Planning Application No: 3/2024/0312

Proposal: Proposed subdivision of first floor flat into two.

Location: High View, Humber Street, Longridge PR3 3WD

**PROPOSED GROUND FLOOR PLAN -
ILLUSTRATING PROPOSED CYCLE STORAGE**
Scale 1:50

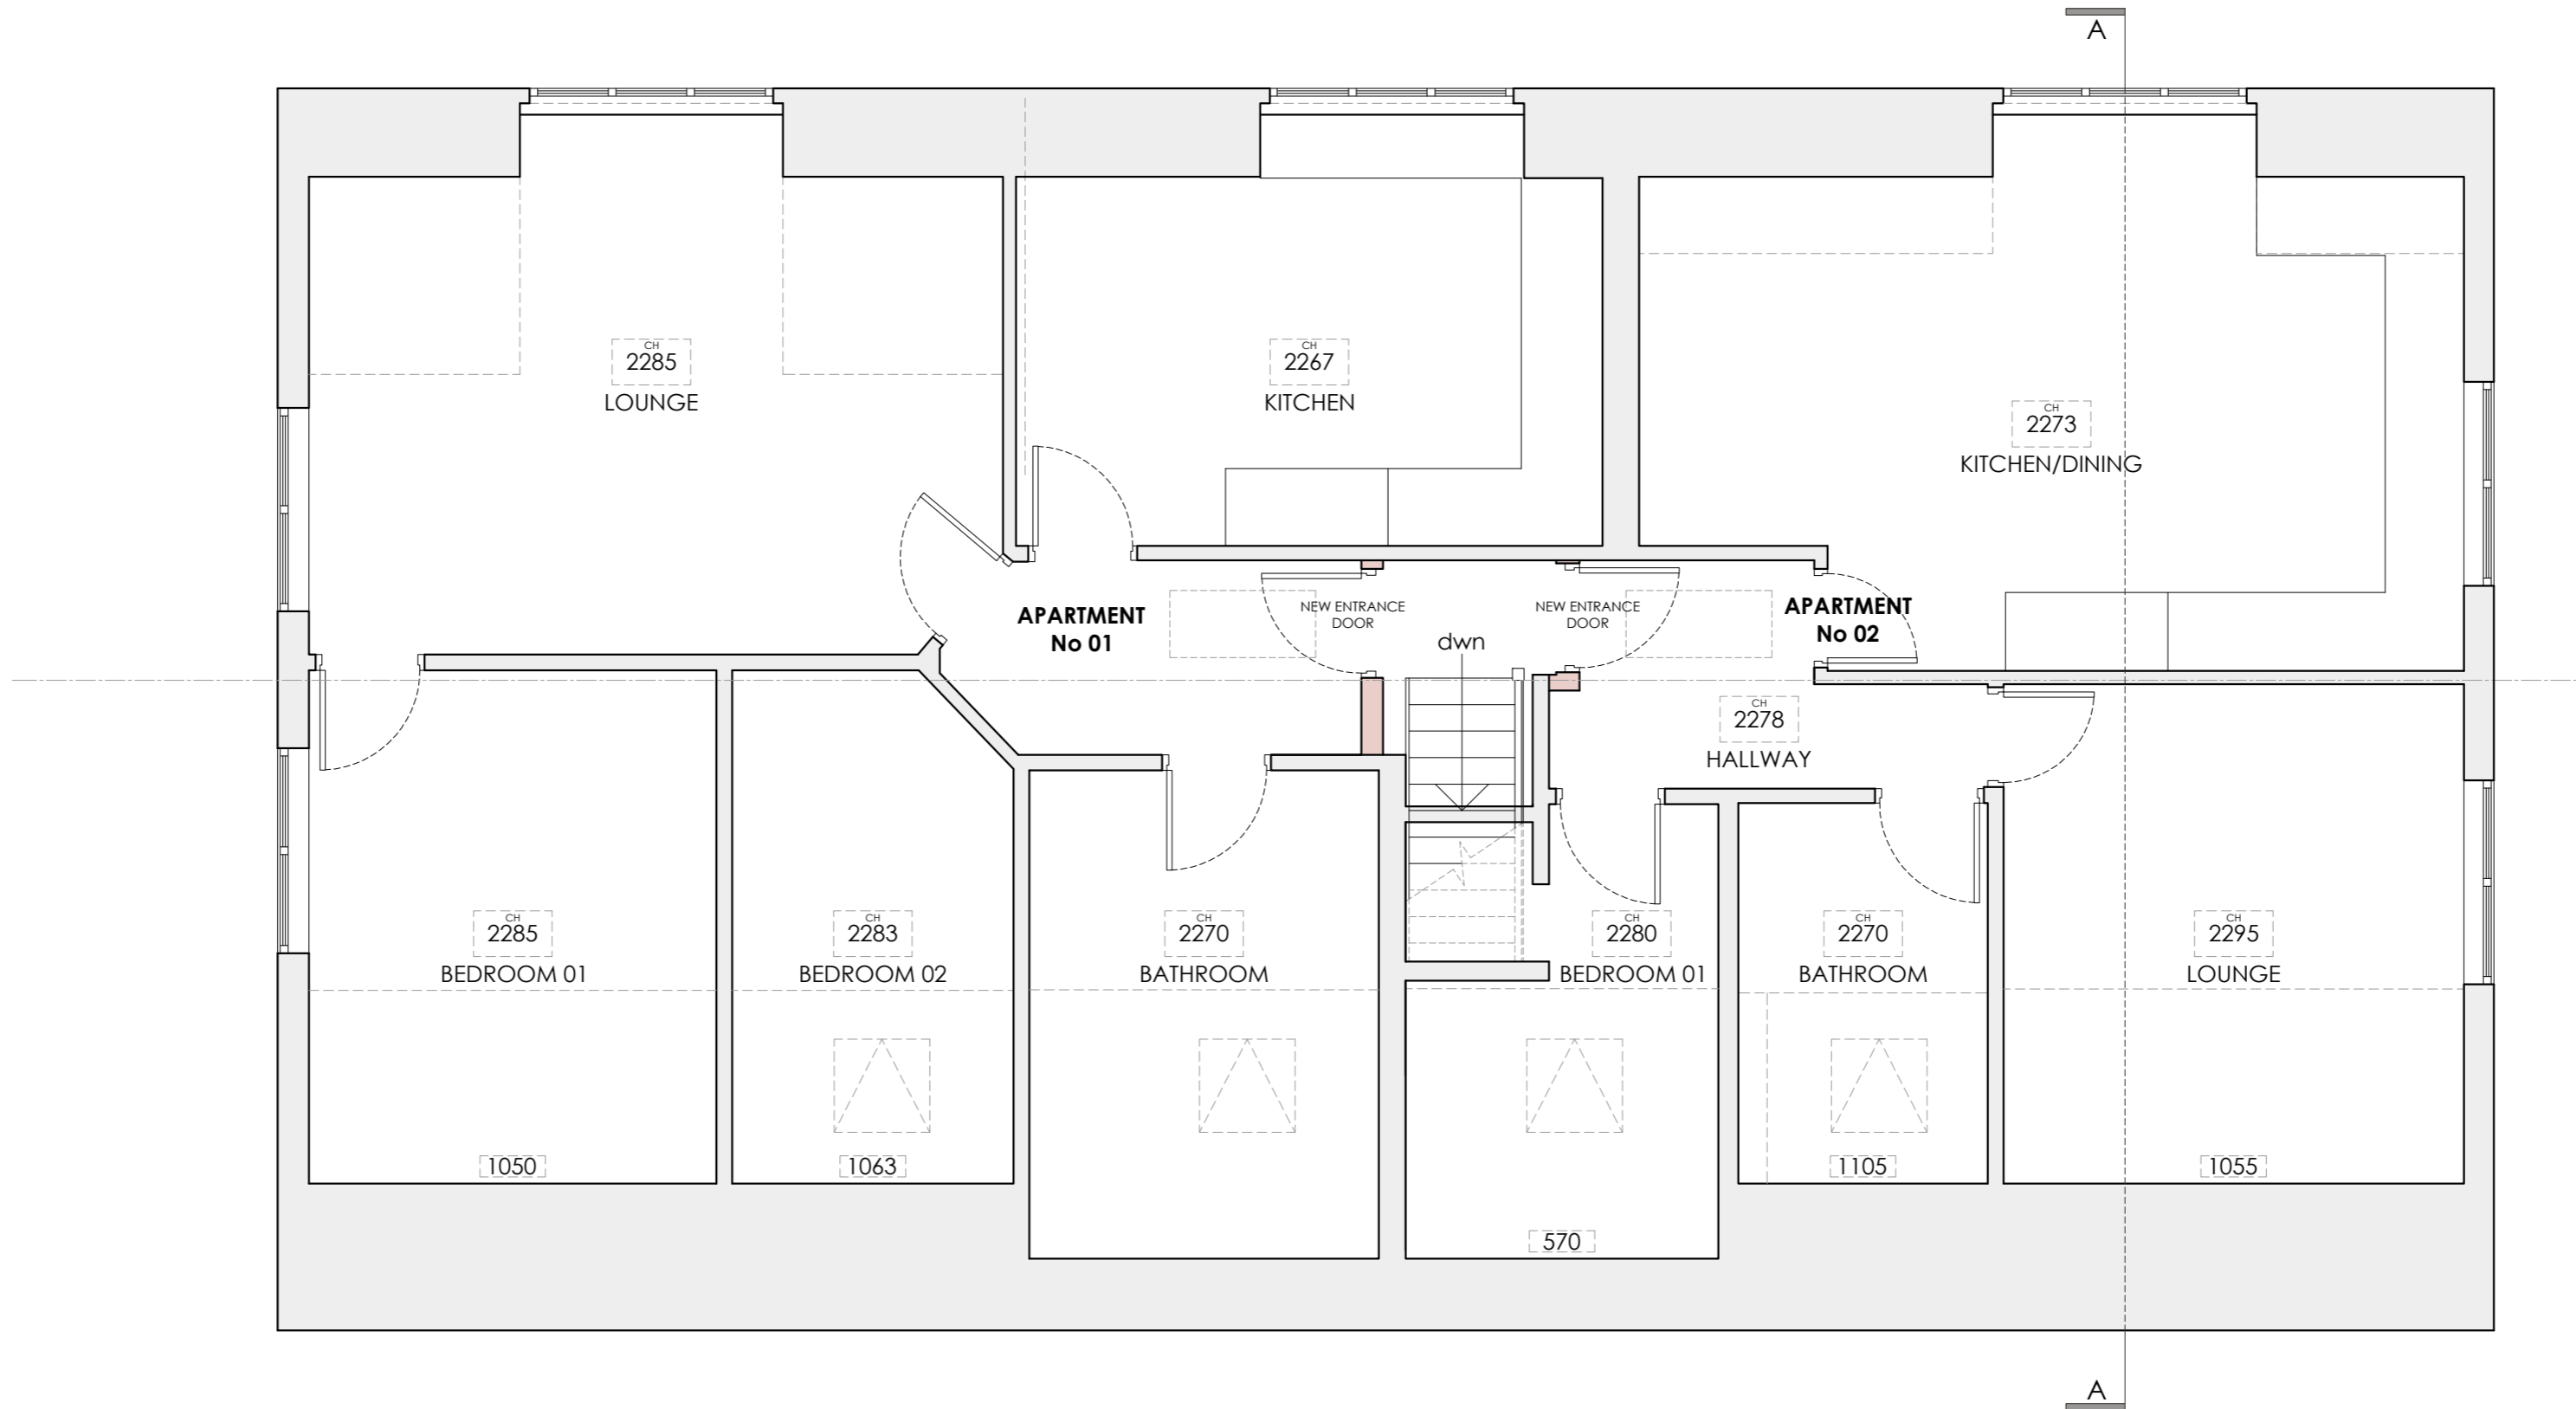
Storage for two cycles is proposed at ground floor level within the entrance hallway. Secure, covered storage, eg cycle lockers, should be provided as the flats will be occupied independently and the storage area is not within nor overlooked by the flats. Details can either be submitted prior to determination of this application or be controlled by condition.

3. Prior to first occupation of the approved development secure, covered cycle storage for at least two cycles shall be provided in accordance with a scheme to be approved by the Local Planning Authority and permanently maintained thereafter. Reason: To ensure that the development provides the infrastructure to support sustainable forms of transport.
